**Re: 4071.10 – The Asylum – Level III Development Review Application
Conditions of Approval**

On May 24, 2016, the City of Portland Planning Board granted site plan approval for the proposed Asylum project at 121 Center Street. To summarize, the applicant is proposing to demolish a portion of the existing 1-story building near the intersection of Center Street and Free Street and replace it with a larger 2-story building addition, construct a new 1-story building addition off Lancaster Lane and construct related site improvements. The Planning Board approved the application with a number of conditions (see below). Enclosed are updated approval drawings that address these conditions.

NO SCALE

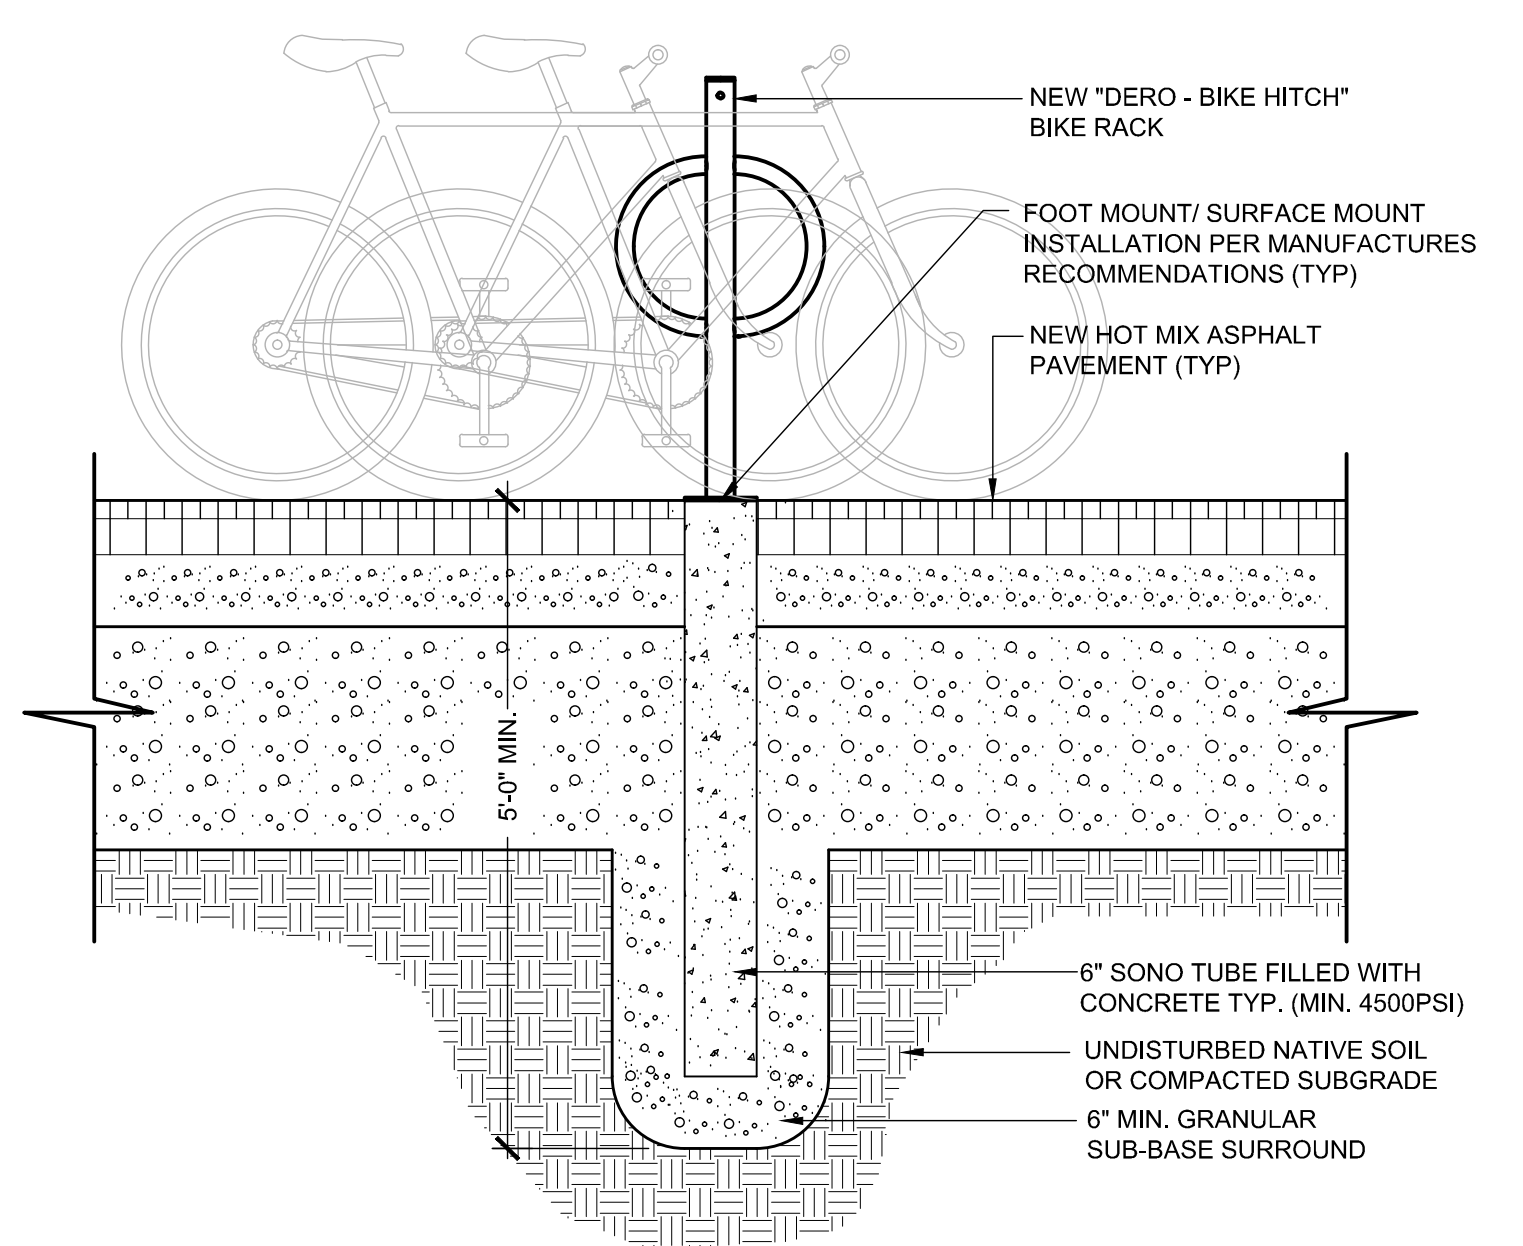
7. Sheet C503 shows a detail of an interior manhole drop connection. These connection are not allowed in city owned and maintained manholes. **Manhole is no longer shown.**

E5 FILTREXX® INLET PROTECTION
NO SCALE

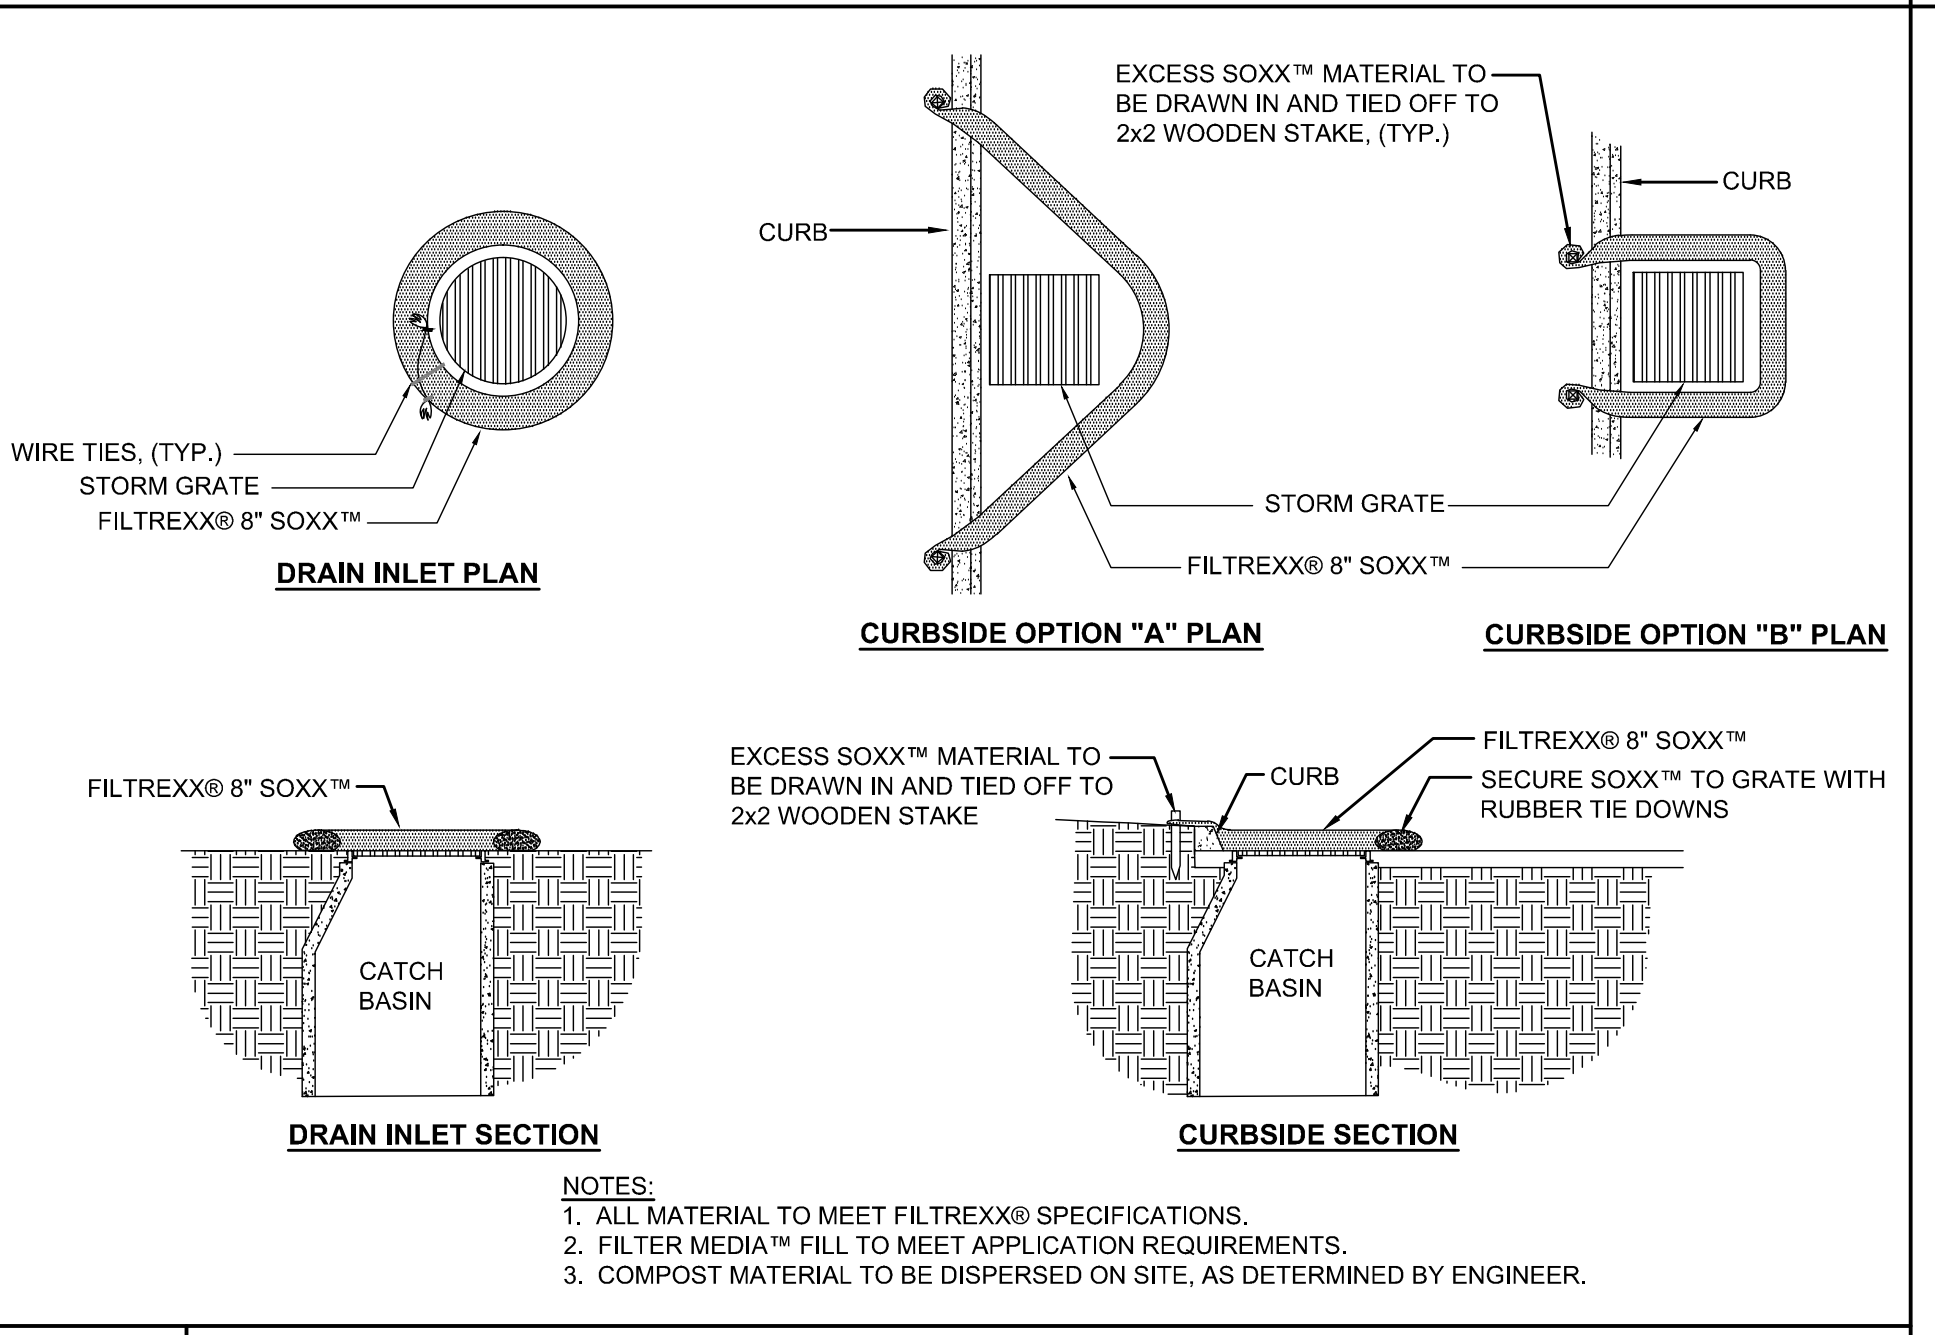
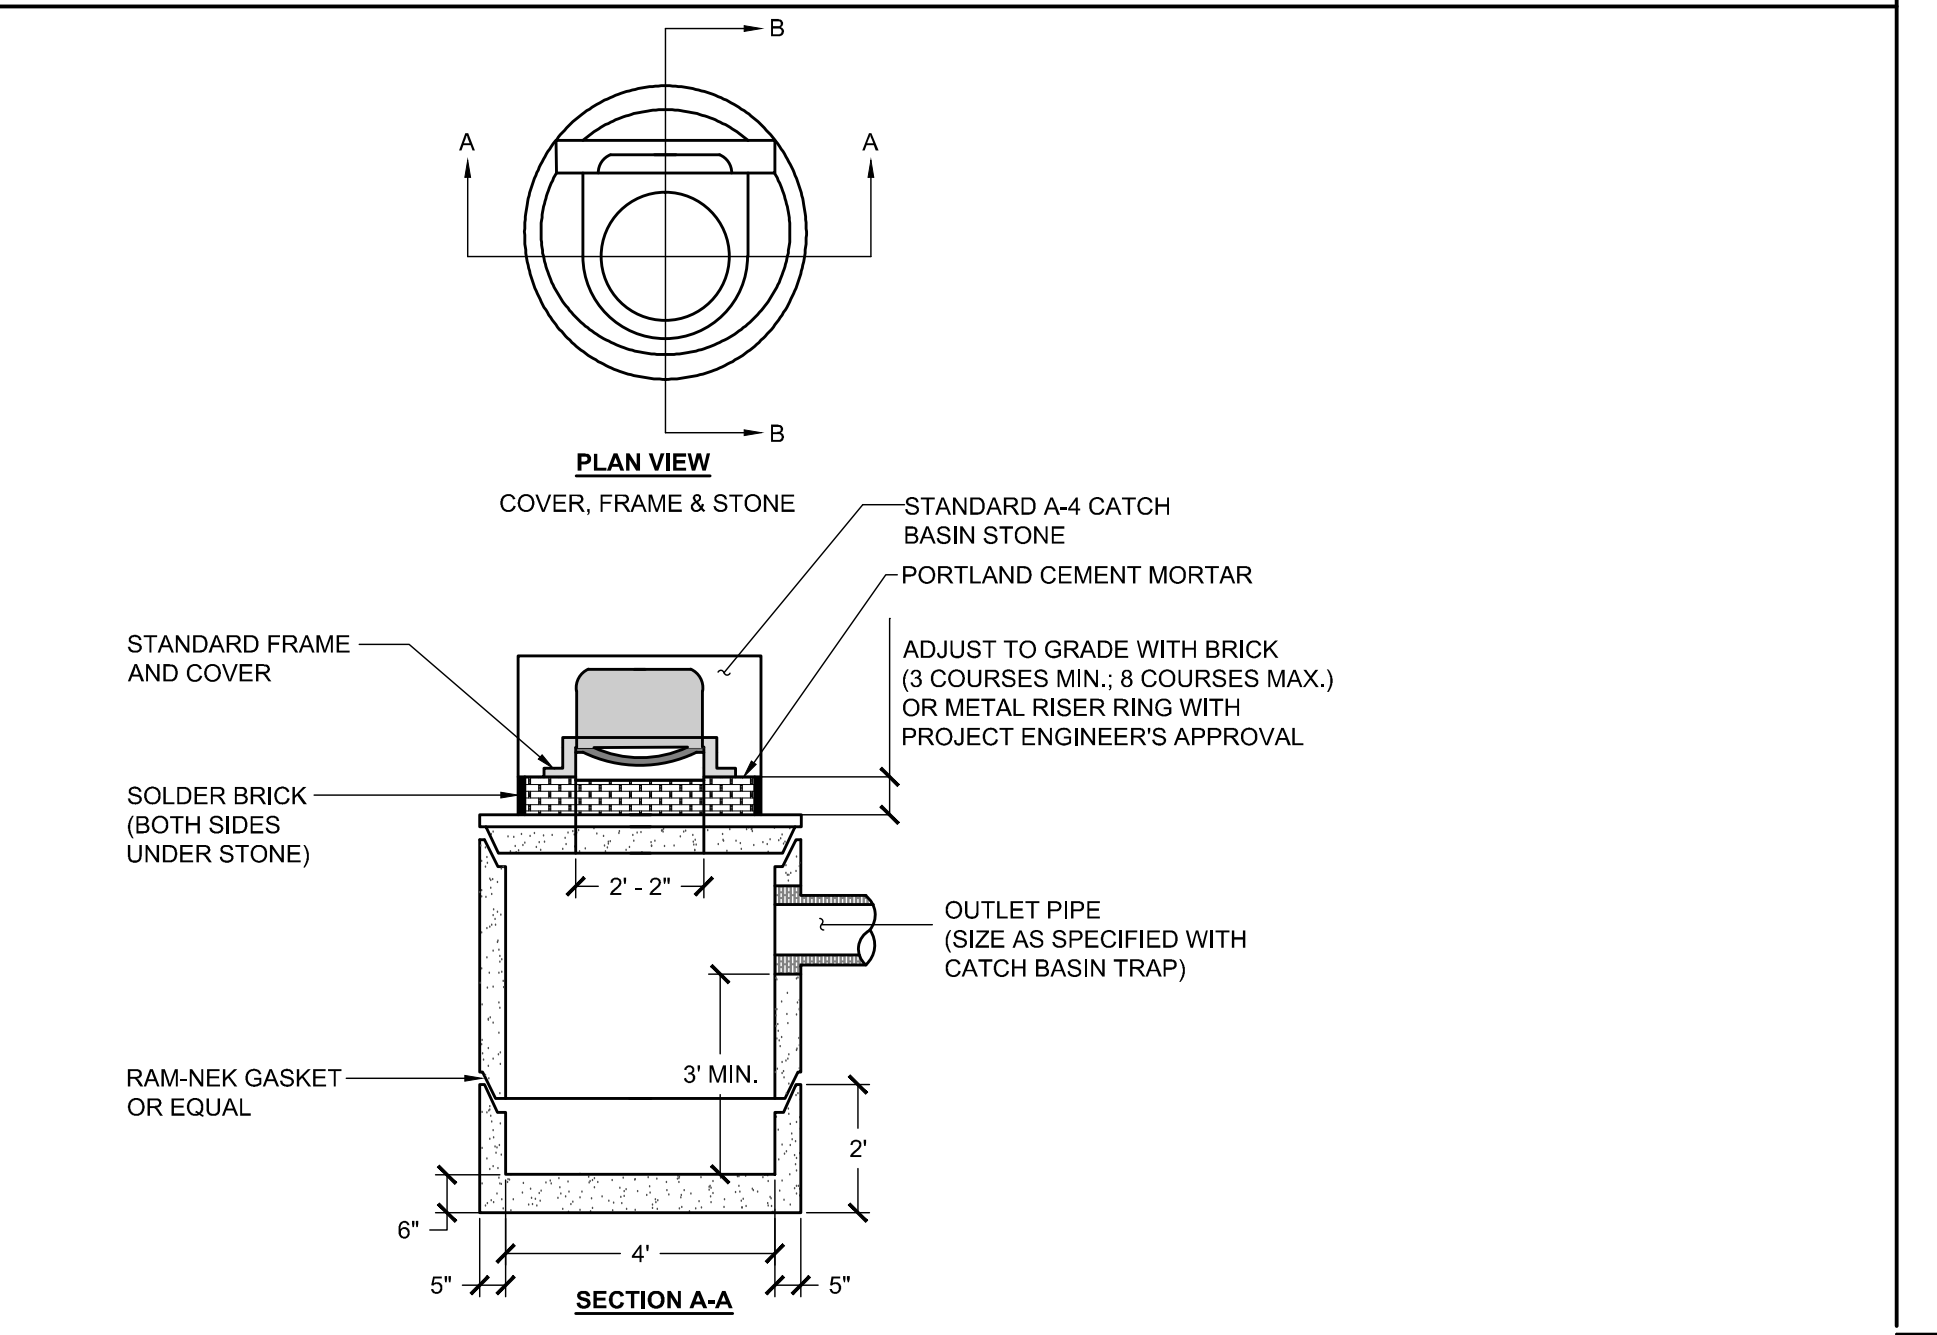
9. That the site plan shall be revised indicating details for the erosion control features specified on the site for review and approval by Lauren Swett, Development Review Engineer. **We added detail E5/C502 to provide additional information for the proposed Filtrexx inlet protection.**
